RESPONSE TO REQUESTS FOR INFORMATION (RFI)

**Proposed Waste Management facility (SSD-62855708)
2-4 Hale Street, Botany**

Reference: 23.464r07v05
Date: September 2025

Notes:

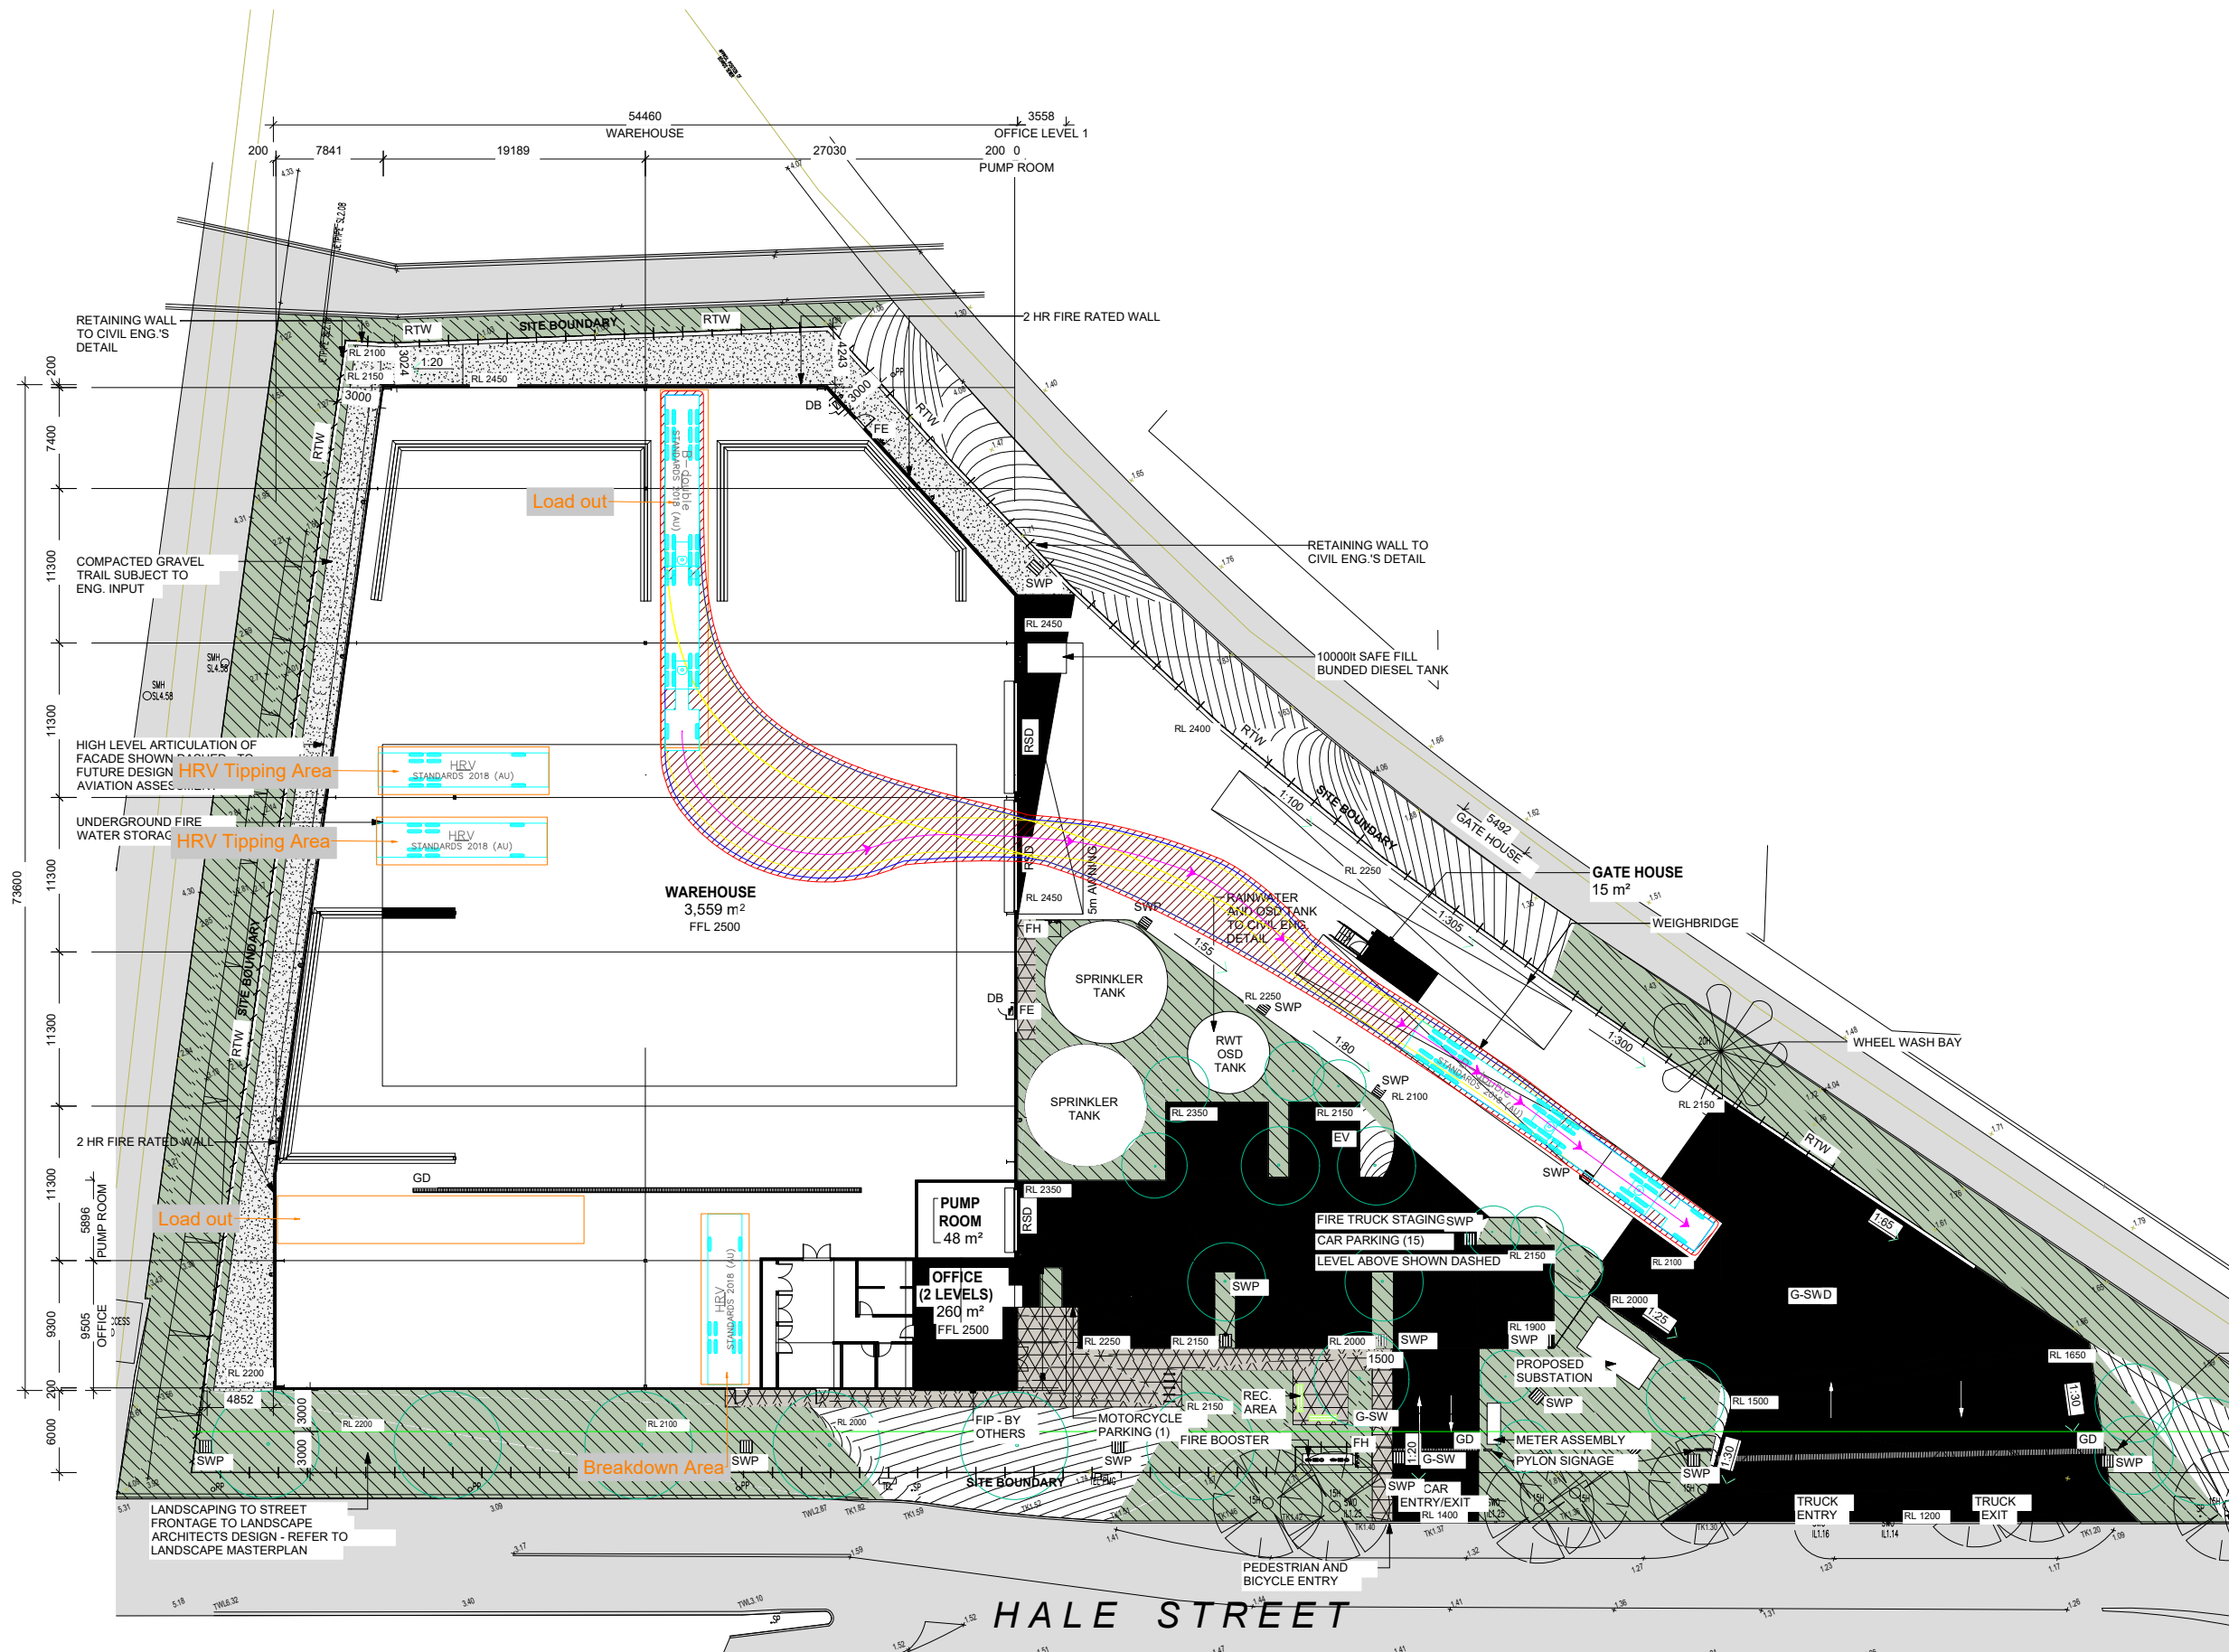
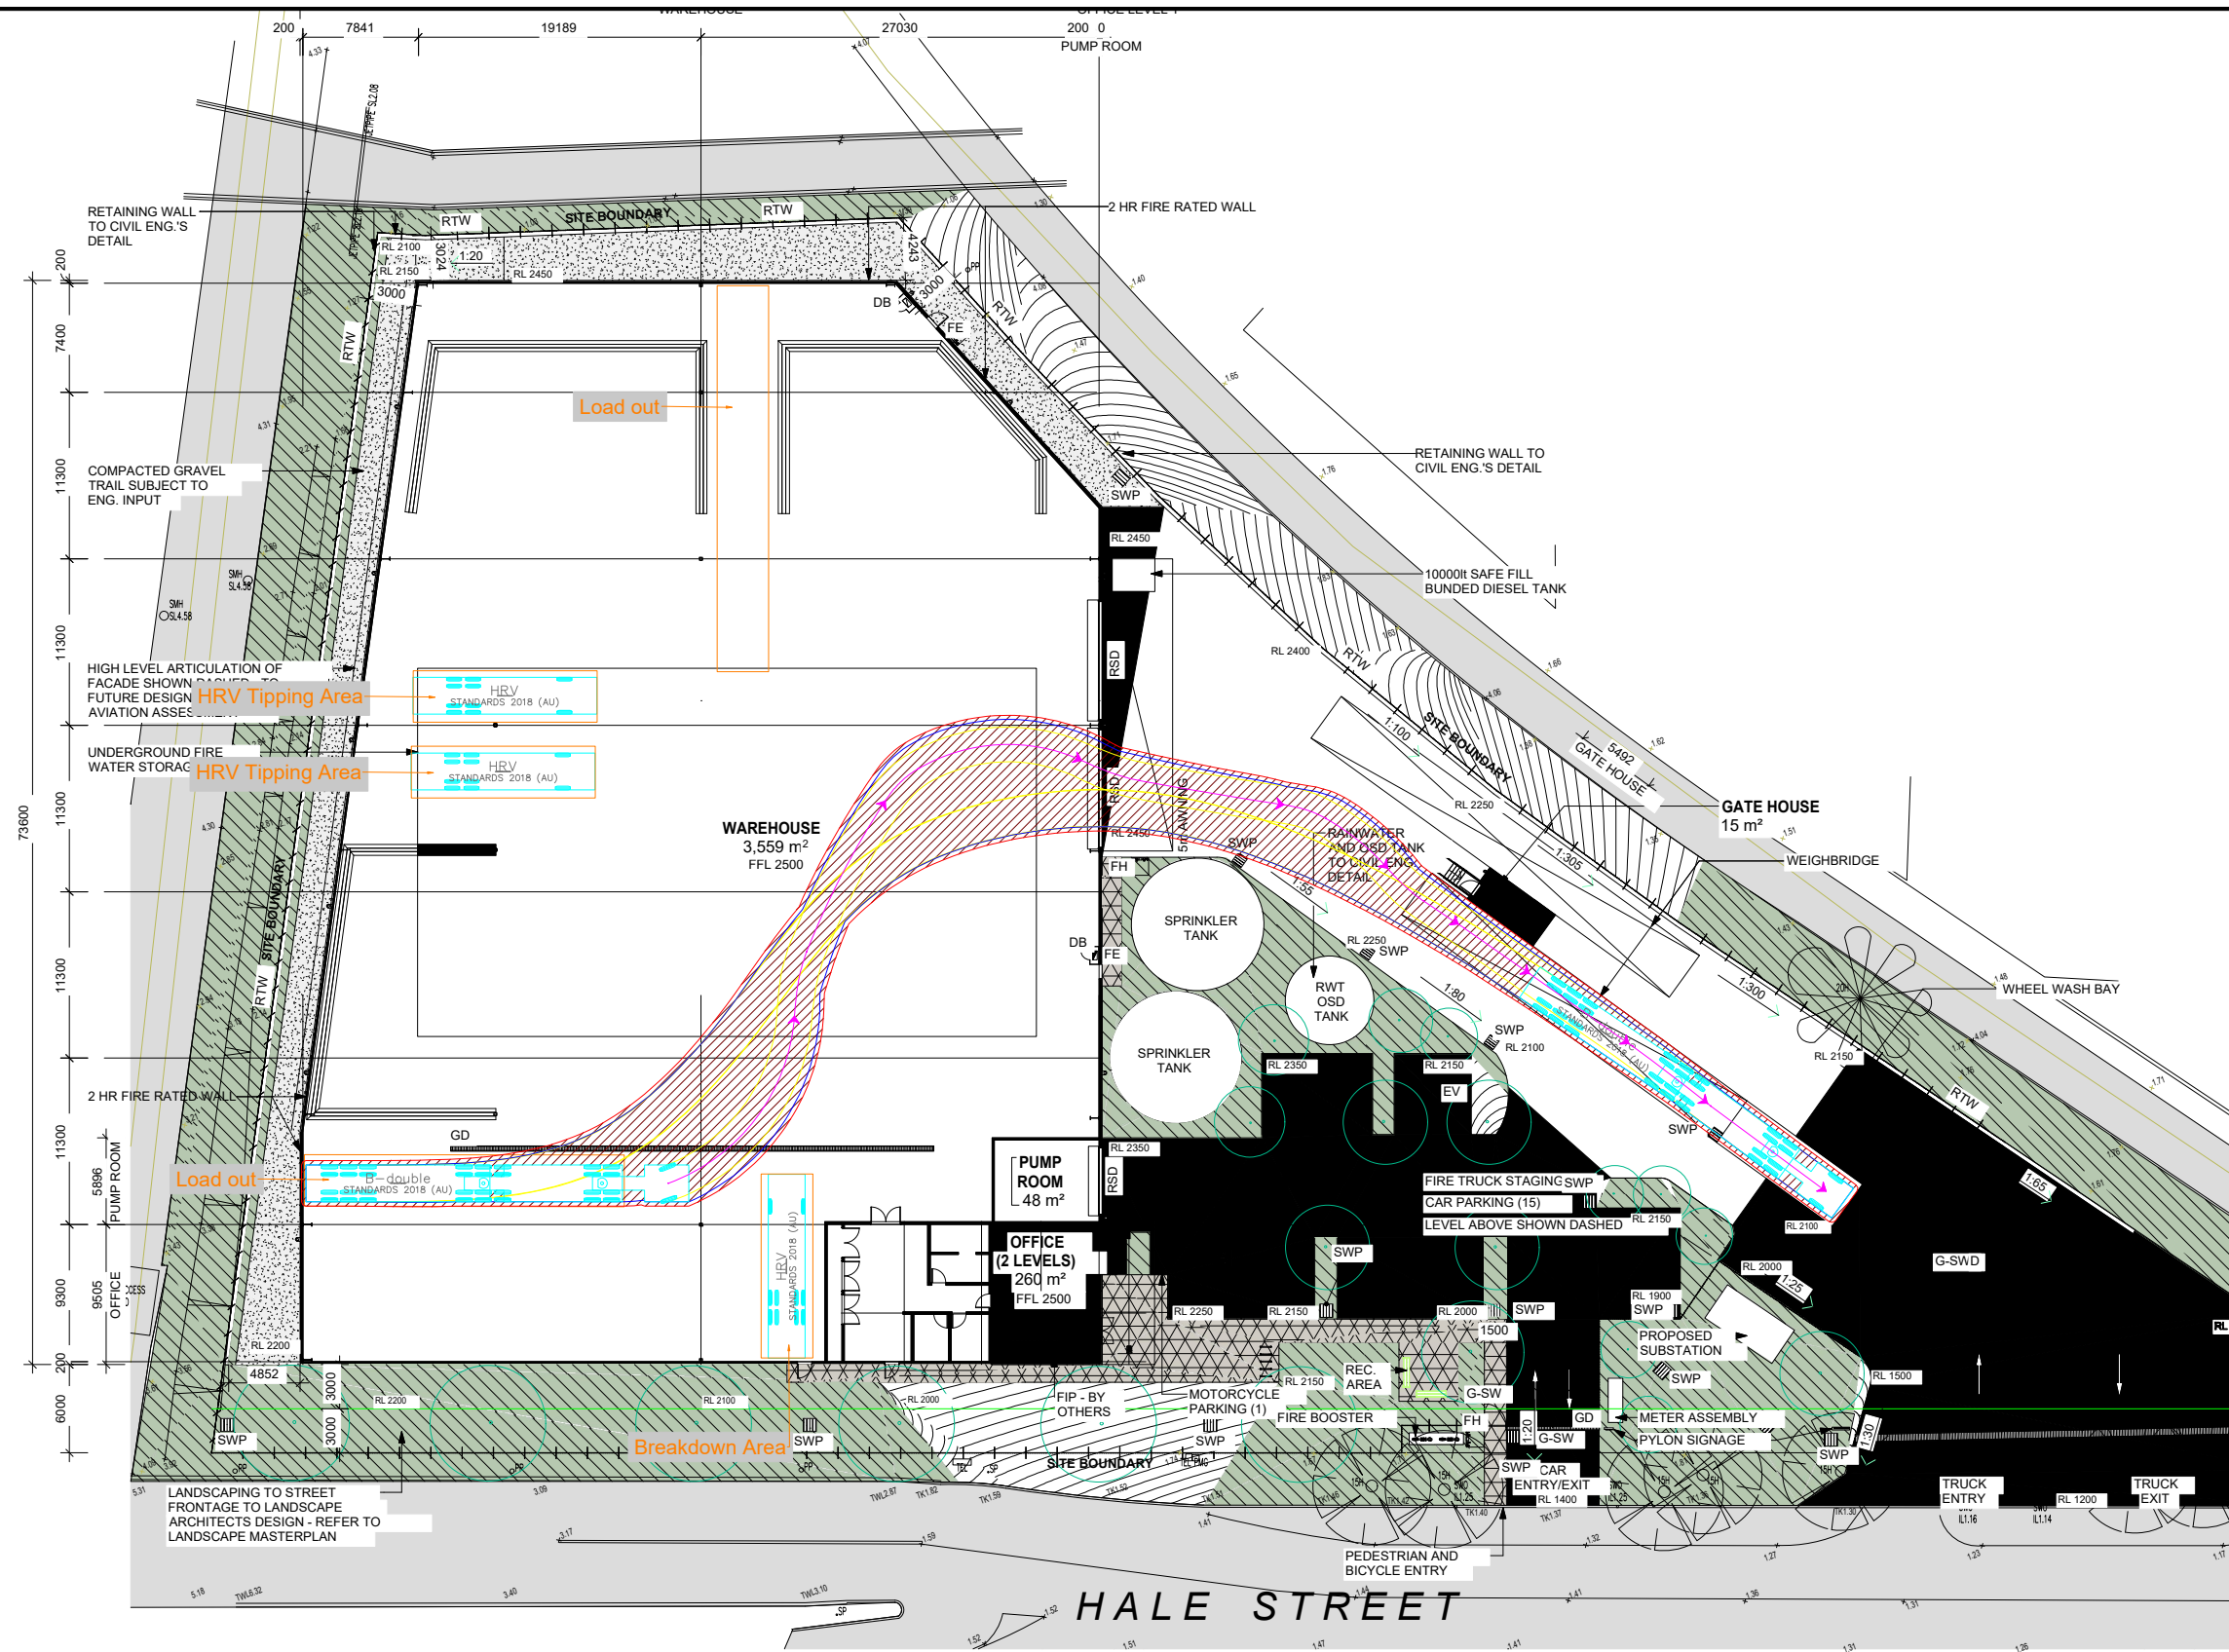
The swept path analysis shows the movement of a B-double exiting the site on a separate drawing to the swept path of a B-double accessing the site. It is not possible to determine if there will be any conflicts if these two movements occur simultaneously. Please provide a plan that shows a B- double entering and exiting the site simultaneously demonstrating that this movement can occur safely and without any conflict to either vehicle or on-street parking, and without crossing the centreline of Hale Street.

- *“Details of how trucks collecting waste will not conflict with incoming vehicles unloading waste – to be supported by commentary and figures clearly demonstrating how this will be achieved.”*

Having considered the above, **Figure 1** below clearly demonstrates a 26m B-double vehicle will be able to satisfactorily enter the site whilst another 26m B-double vehicle is waiting to exit the site, under conservative operational assumptions.

Reference should be made to the swept path analysis provided in **Attachment 3** showing the satisfactory truck movements to / from the proposed breakdown bay. Implementation of measures as part of an operational traffic management plan is an enforcement matter is to be addressed by the operator.
